Ribble Valley Borough Council

## DELEGATED ITEM FILE REPORT - APPROVAL

3/2014/0664/P

Two no. roof lights at 14 Goose Lane, Cottages, Chipping, PR3 2QF. Resubmission of application 3/2014/0275/P.

PROPOSED FRONT ELEVATION (North)

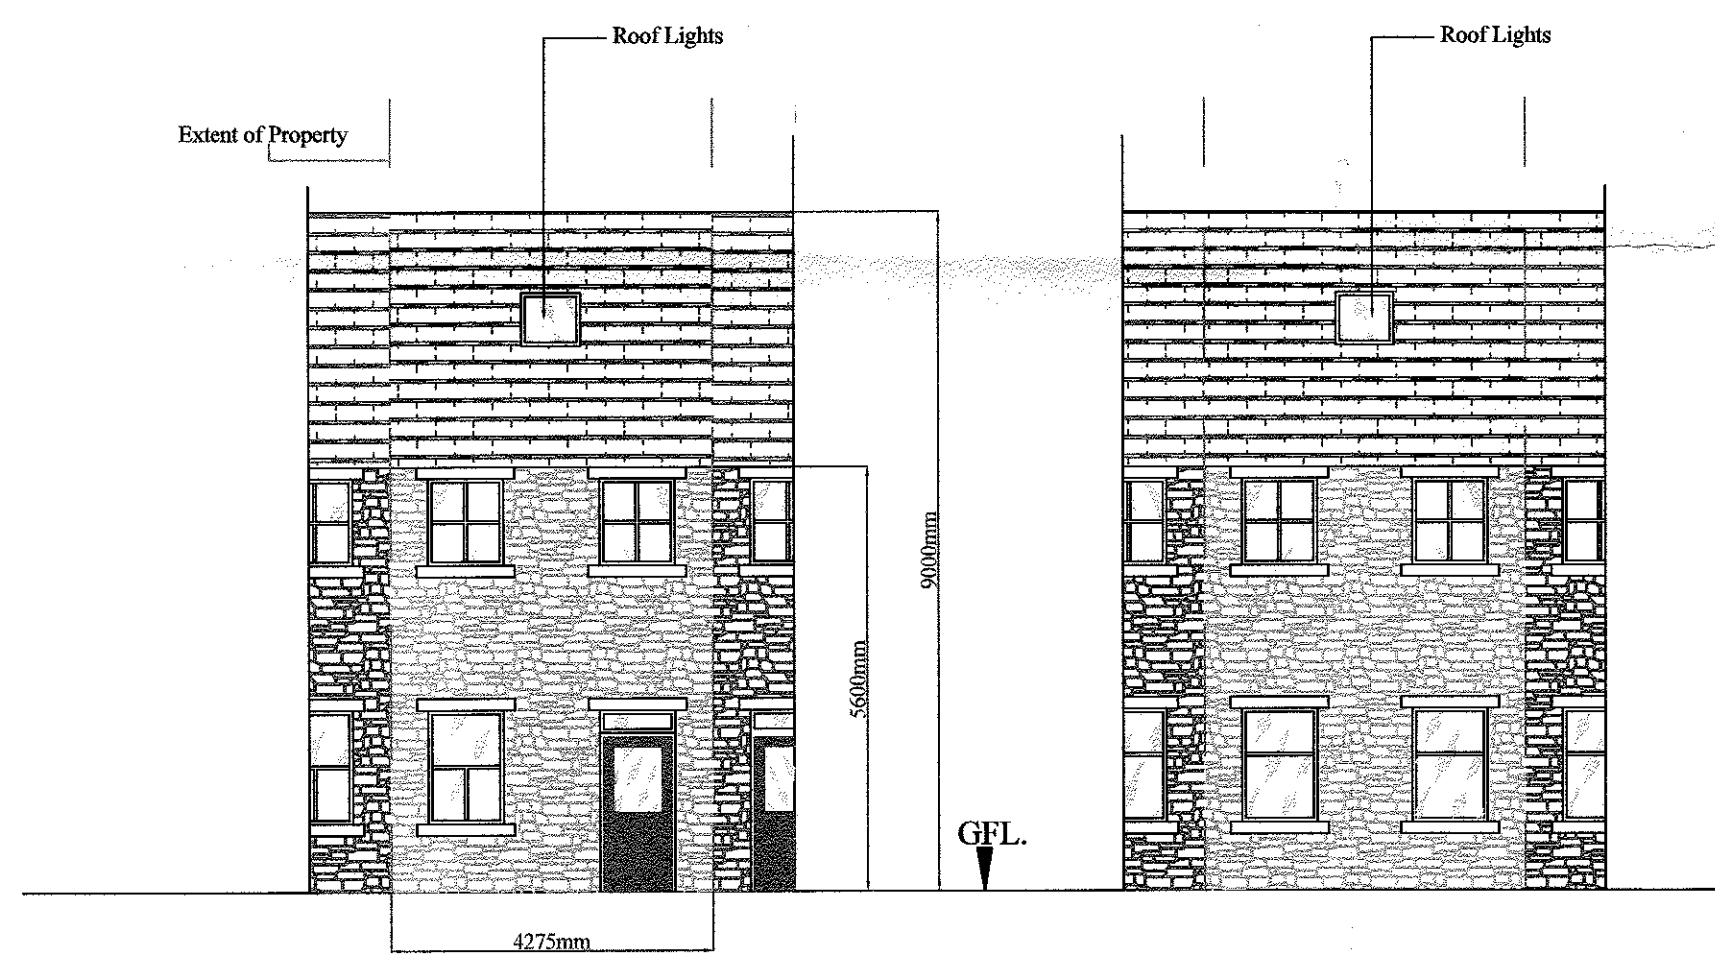
The building to which the building forms part is a traditional rural building set within an area of undulating lowland farmland. The building is thus seen from long range views north and southwards, however, it is the front elevation of the building that is considered to be its principal elevation and there are long range views of this from Goose Lane across open fields and it is considered that it is this front roofslope that must be protected from harmful insertions.

PROPOSED REAR ELEVATION (South)

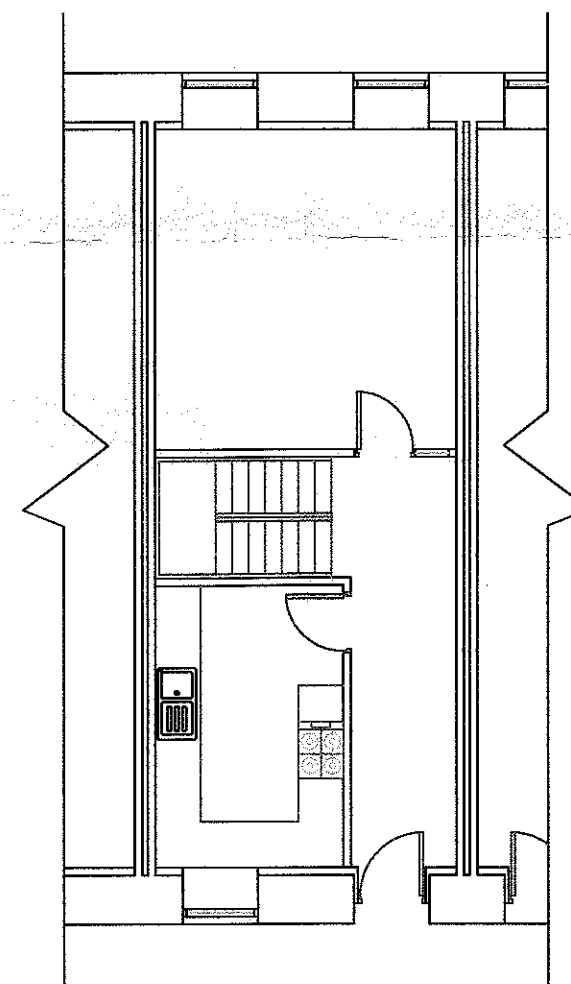
The insertion of two roof lights on the rear roofslope is considered to be the least harmful visually, and I thus recommend the application be approved in accordance with the amended plans received on the 11 August 2014 which illustrated the rooflights relocated to the rear elevation.
